Application No: BR/83/22/PL
Site Address: Unit 10 Arun Business Park Shripney Road Bognor Regis PO22 9SX
Description of works: Addition of two first floor windows at rear of property. This application is in CIL Zone 4 (Zero Rated) as other development.

OWQC47590

Proposed Office Layout
Option #1

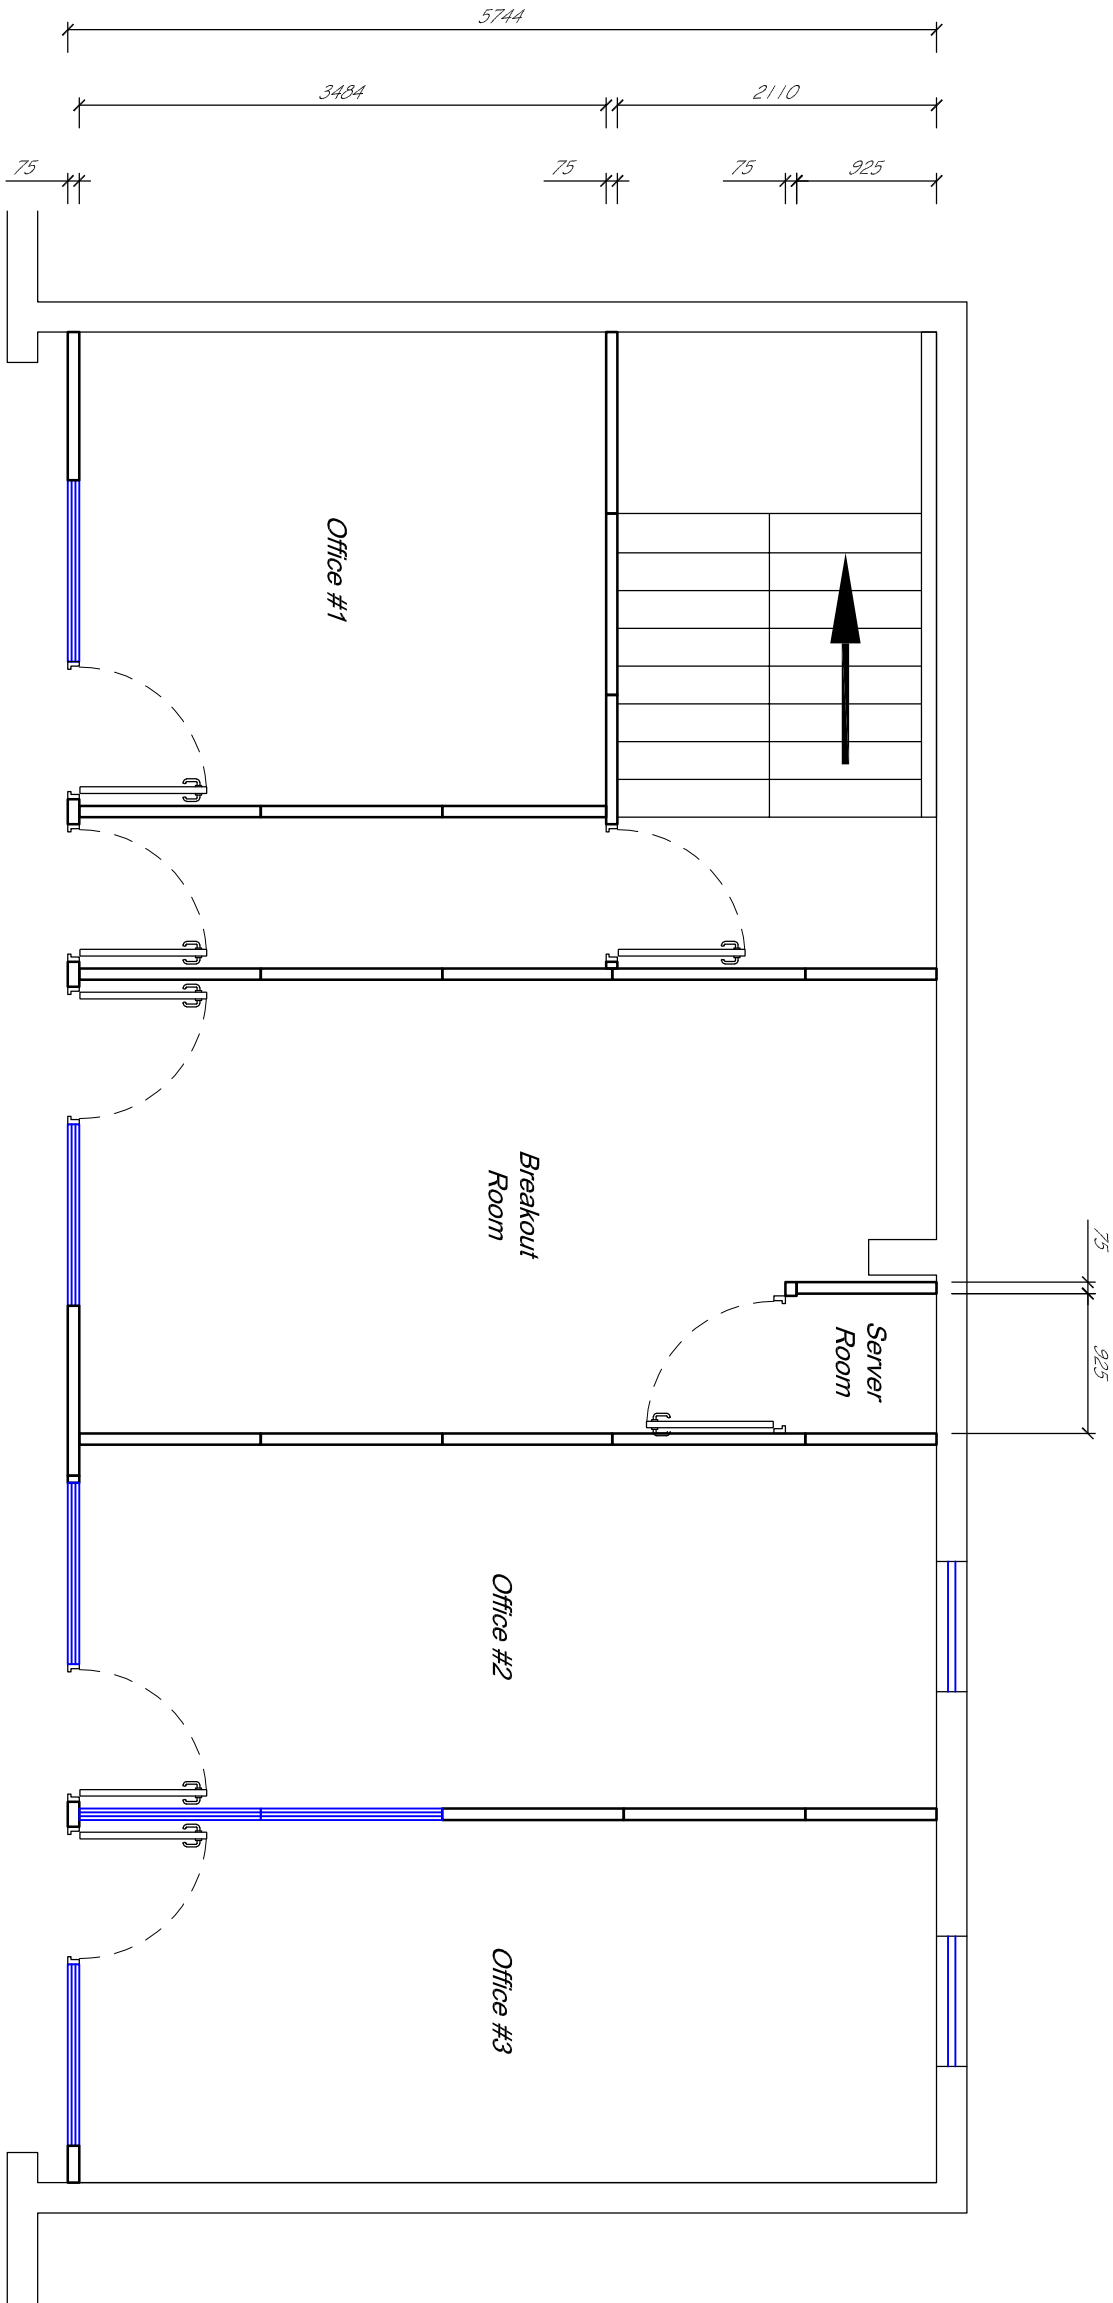
NO OBJECTION Members have no objection, in principle, to planning application BR/83/22/PL. However, having taken onboard the comments and concerns of neighbouring householders, the Committee would like to request that the applicant considers the use of privacy film on glass, or opaque/frosted panes, in the proposed windows.
